Online Comment

Application H17-1026-23
Location 5 LOW GATE SURFLEET SPALDING PE11 4AS
Proposal Proposed open front store

Front Elevation

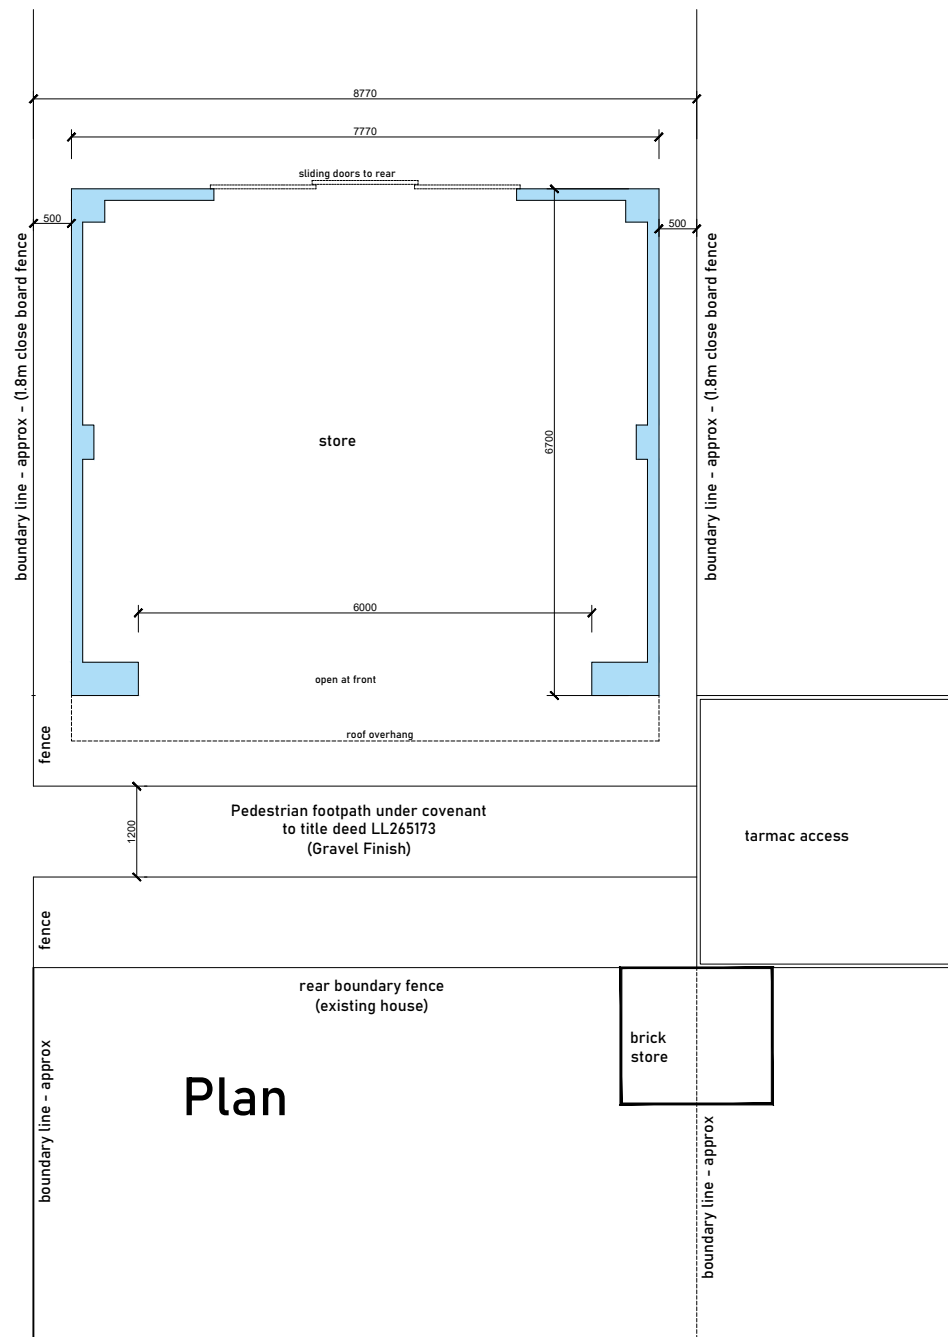
Major concerns with the size of the intended structure which is not in keeping with neighbouring properties.
Location of the structure would be 500mm from Council owned property boundaries. The materials stated to construct would not meet current building regulations.
The additional proposed fencing would encroach onto shared roadway. The plan incorrectly states that this is a pedestrian footpath but is actually vehicular access shared with neighbouring properties
